App: AL/121/21/PL

Proposal: Demolition of swimming pool buildings and erection of 1 No. new dwelling using the existing access.
This site is in CIL Zone 2 & is CIL Liable as new dwelling.

Address: Rear of Green Gables, Northfields Lane, Westergate, PO20 3UH

Figure 1: Land At Green Gables Habitat S Survey Map

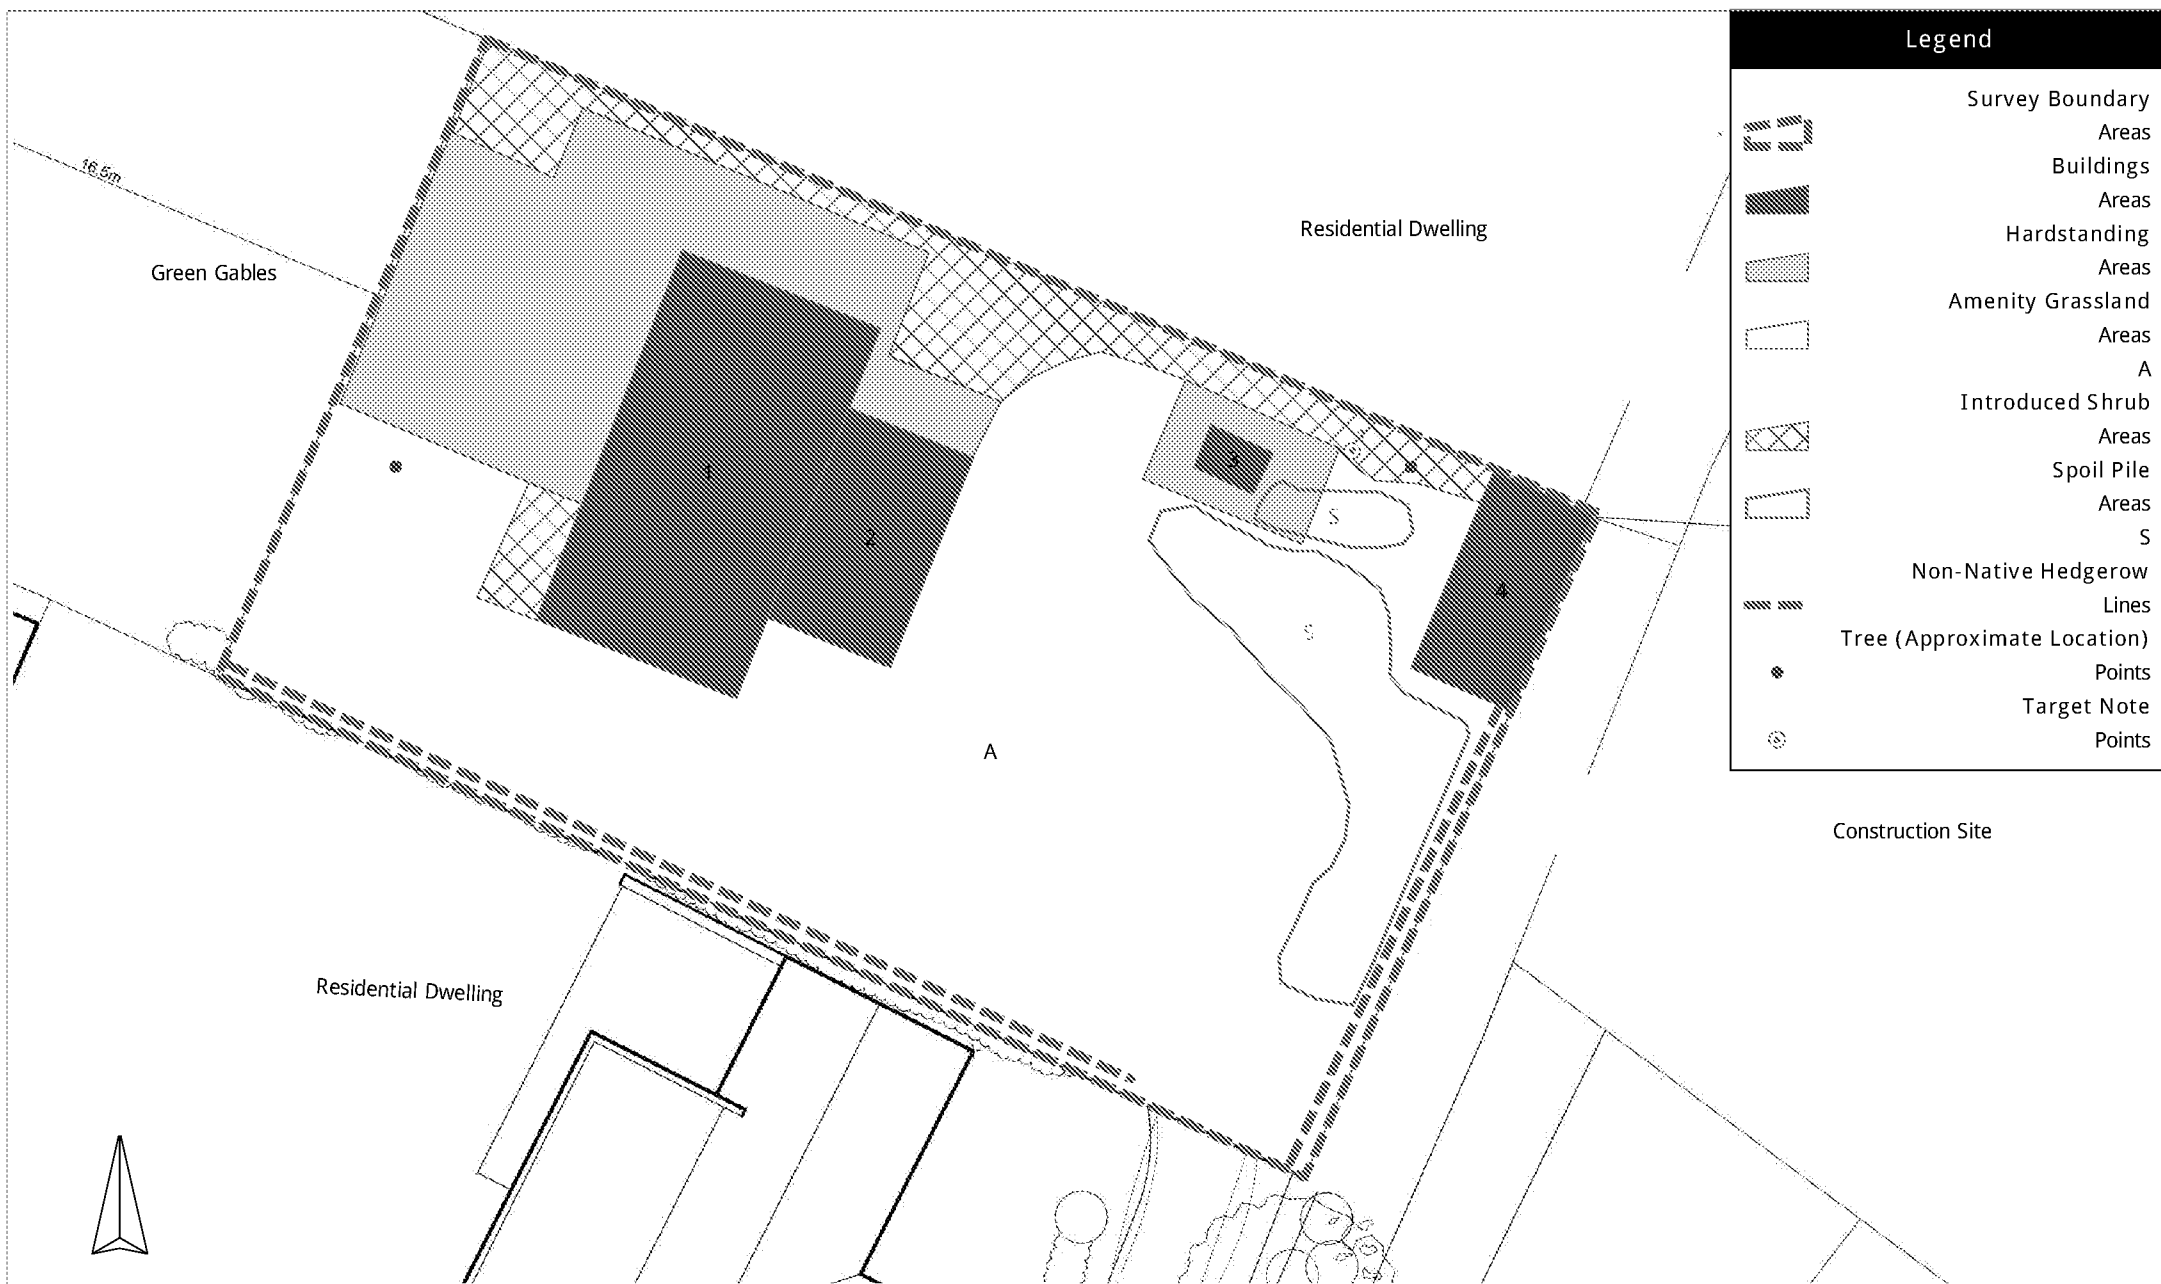
We note that one tree is due to be removed. To ensure no net biodiversity loss we require one replacement native tree to be planted. A condition should be used to ensure this.
